TOWN AND COUNTRY PLANNING ACT 1990

Reference: H14-0454-26 **Date of Decision:** 26th June 2026
Applicant: Dorset Carpentry & Building (Mr S Twelves)
Sunnyside
Langhole Drove
Pinchbeck
Spalding
PE11 3XP
Location: Sunnyside Langhole Drove Pinchbeck Spalding
Description: Two Storey Side Extension and Single Storey Utility Extension

Elevation 01 - Front
1 : 100

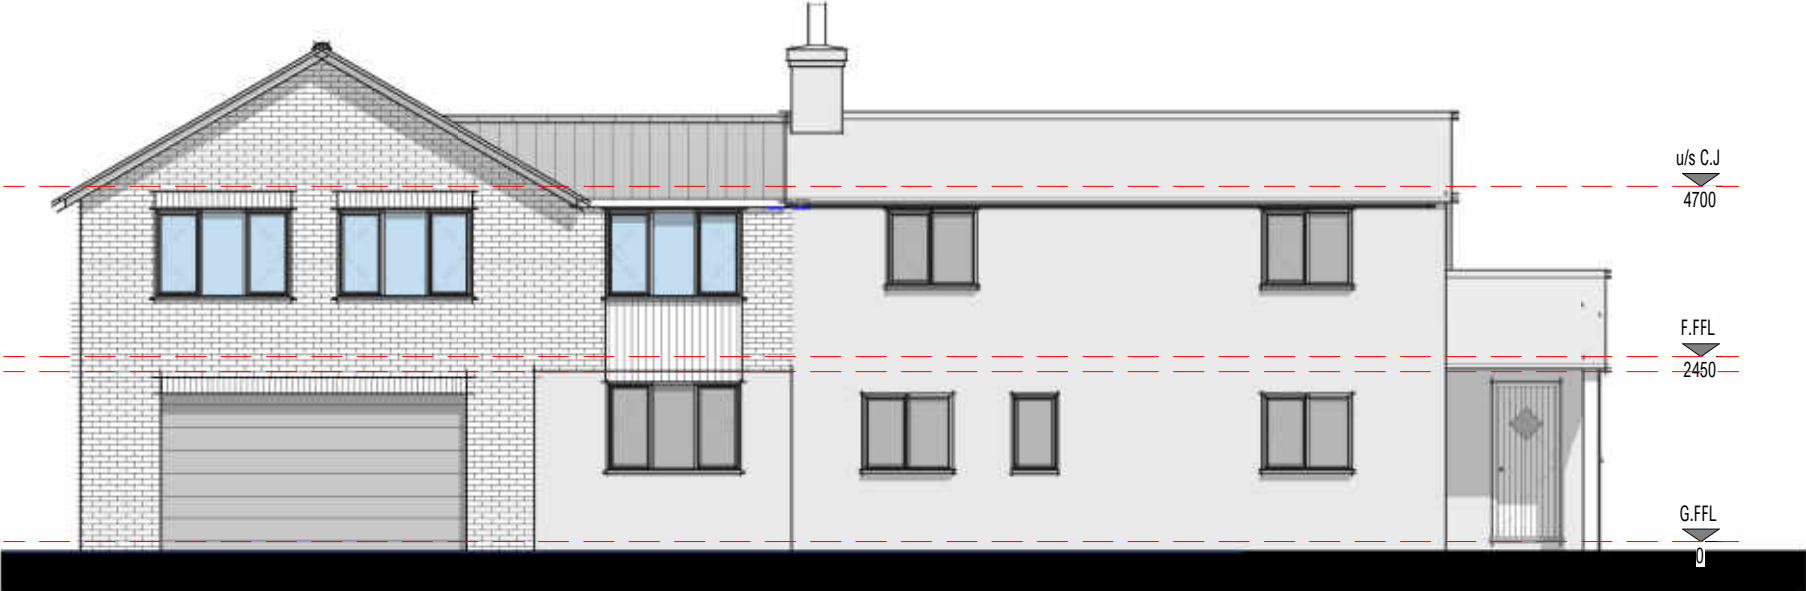
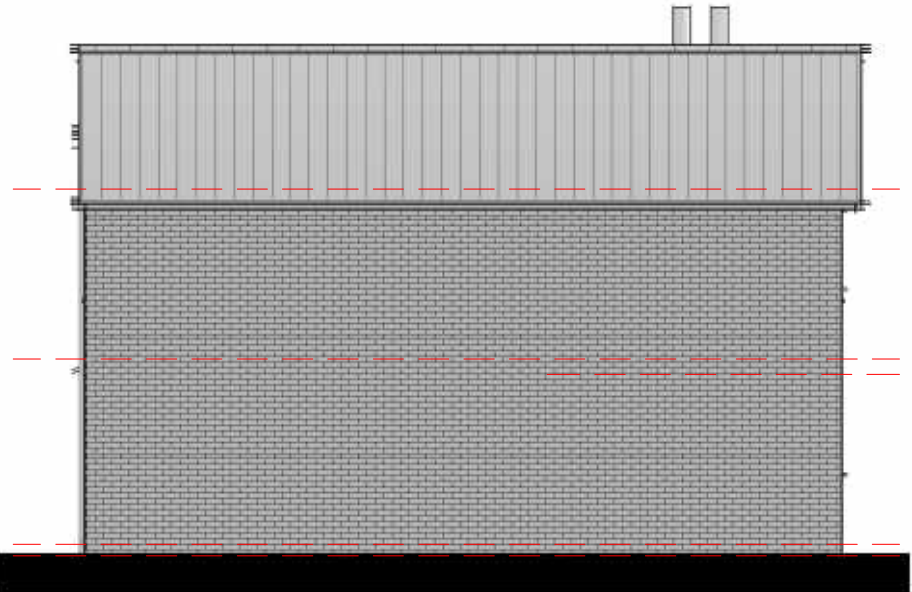
- 1 It is considered that the proposed two-storey extension would be unduly large and would fail to respect the existing proportions of the dwelling. The extension is considered to relate poorly to the host, failing to integrate itself into the host or to create an adequate subservient relationship. The result is an overly bulky and oversized appearance which fails to reflect the principles outlined within Policies 2 and 3 of the South East Lincolnshire Local Plan, 2019 and Section 12 of the National Planning Policy Framework, December 2024, thereby constituting harm to the character and appearance of the dwelling and the area. The extent of the harm would outweigh the limited benefits of the scheme in the planning balance.

The proposal is therefore considered to be contrary to Policies 2 and 3 of the South East Lincolnshire Local Plan, 2019, in design terms, as well as Section 12 of the National Planning Policy Framework, December 2024.
